98, Elmer Road, Middleton On Sea, Bognor Regis
Proposed Extensions & Alterations & Extended Parking Area
Application No. M/114/17/HH

Further to your e.mail communication dated 14th November 2017 I enclose two copies the following amended information as requested in your e.mial.

Front Elevation ~ As Proposed

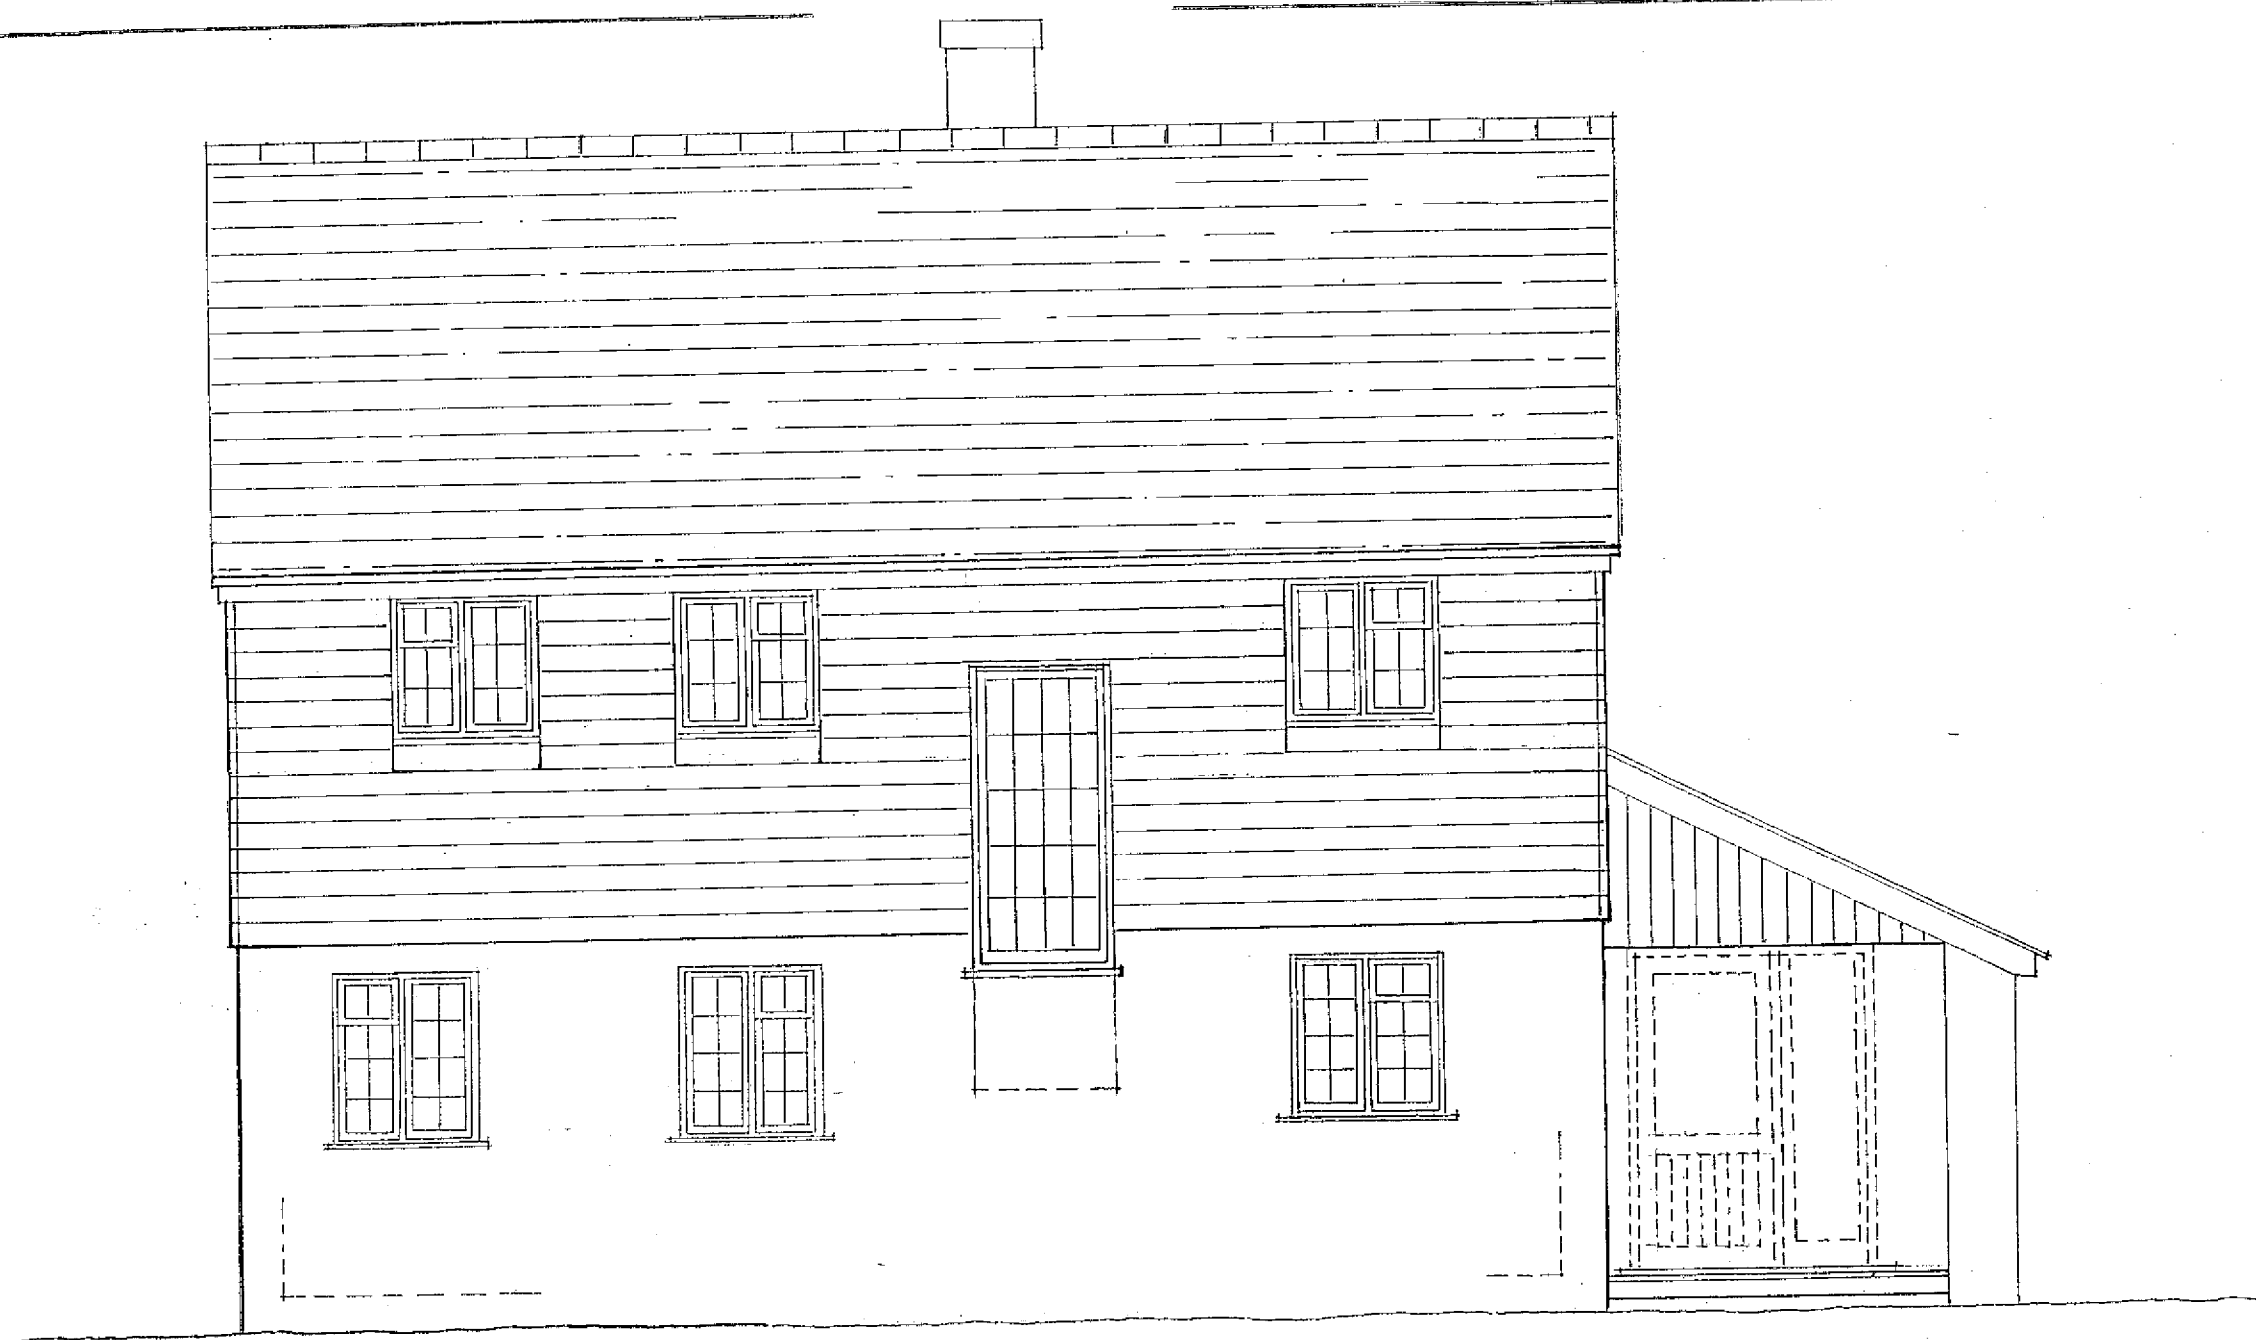
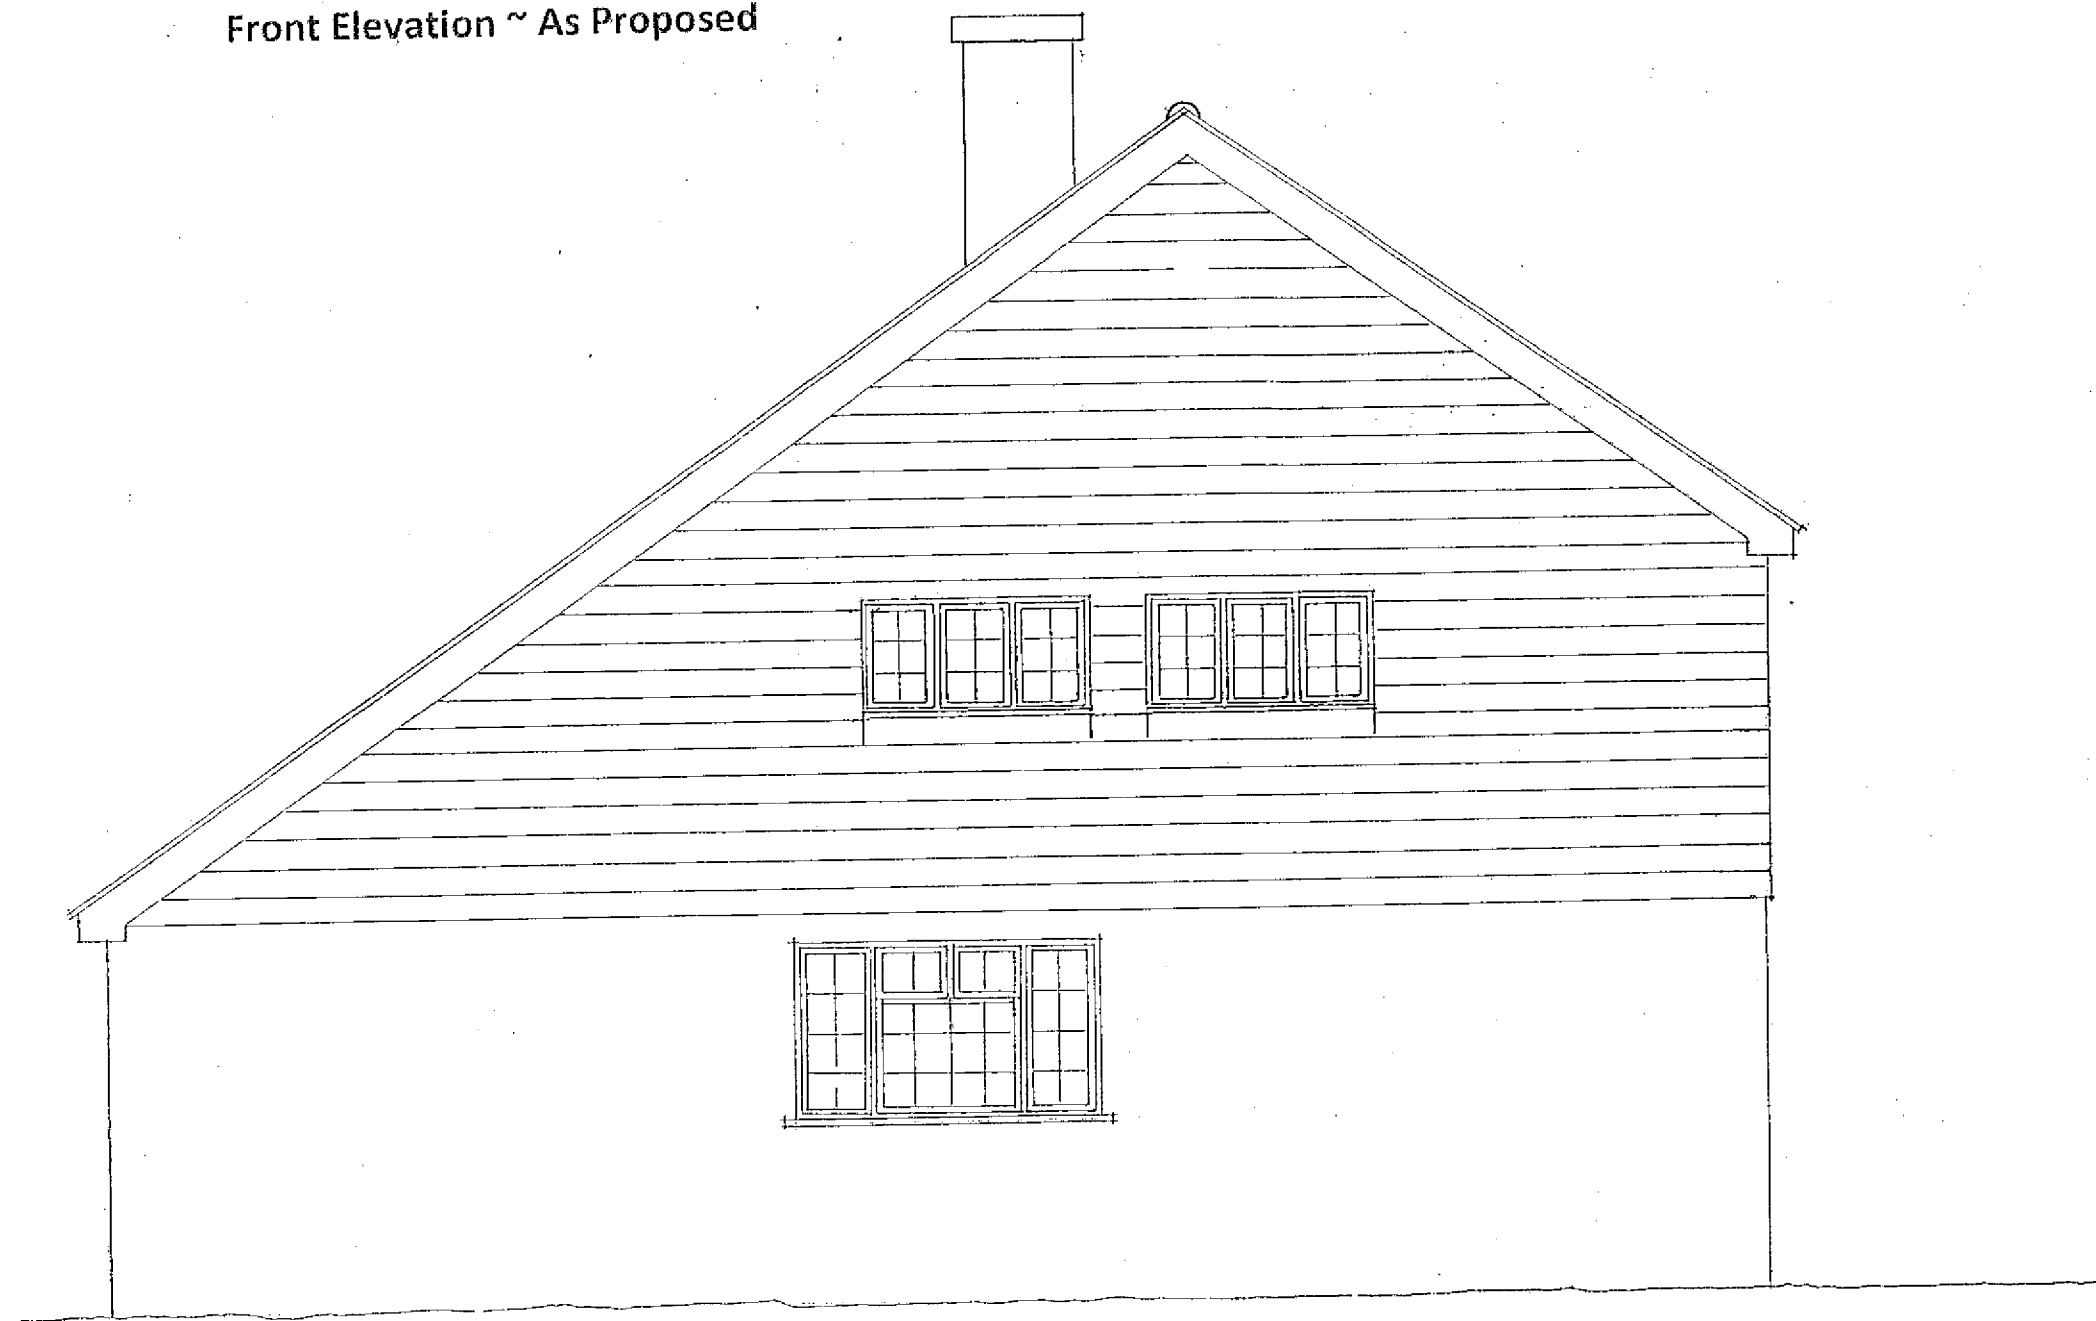
- 1) Block Plans showing distances to boundaries.
- 2) Proposed elevations with the correct orientations added.
- 3) Existing Ground Floor Plan amended with the staircase window shown.
- 4) Proposed ground/first floor plan amended with the staircase window shown.
